Director Infrastructure Projects
Department of Planning and Environment
Major Projects Assessment
GPO Box 39
SYDNEY NSW 2001

PROPOSED NORTHCONNEX M1 / M2 TUNNEL PROJECT - Application Number - SSI 13_6136
We object to many aspects of this project

MOTORWAY OPERATIONS COMPLEX - SOUTHERN VENTILATION FACILITY - SECTIONS
M1-M2-5000-DR-JD-0525

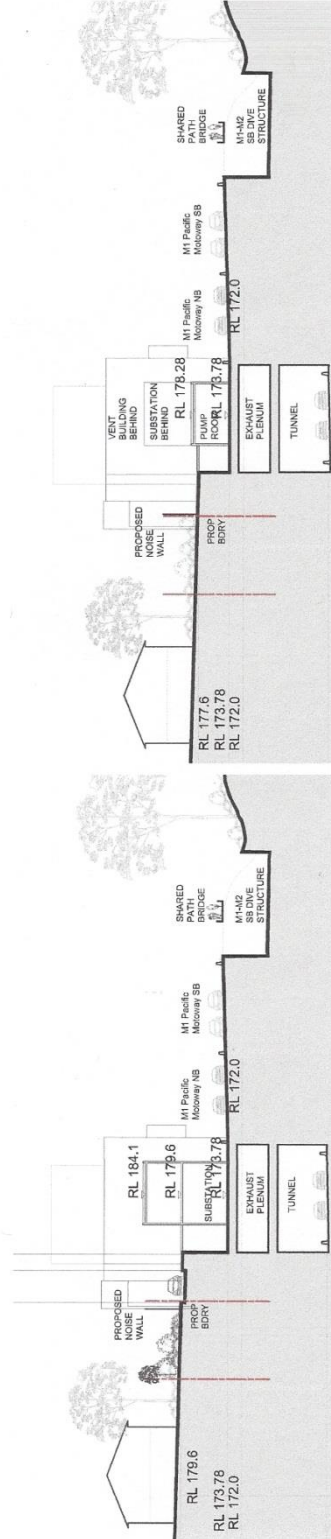
1. The Environmental Impact Statement (EIS) does not show any connection between the ventilation stack and the southbound tunnel which is 250 metres away. Will the polluted air be allowed to flow like an invisible sewer through West Pennant Hills, North Rocks, Carlingford and Beecroft?
ACTION: Provision of diagrams and detailed description of what ventilation is proposed for the southbound tunnel at the Southern Interchange. We would like the opportunity to lodge further submissions once that has been provided.

2. The ventilation stack should be located immediately above the tunnels on the corner of the Pennant Hills Golf Course and the M2. NorthConnex admit that this is the most efficient location for the stack. Why is the stack not being correctly located and positioned as far as possible away from homes?
ACTION: Purchase of golf course land to position the stack in its most effective location.
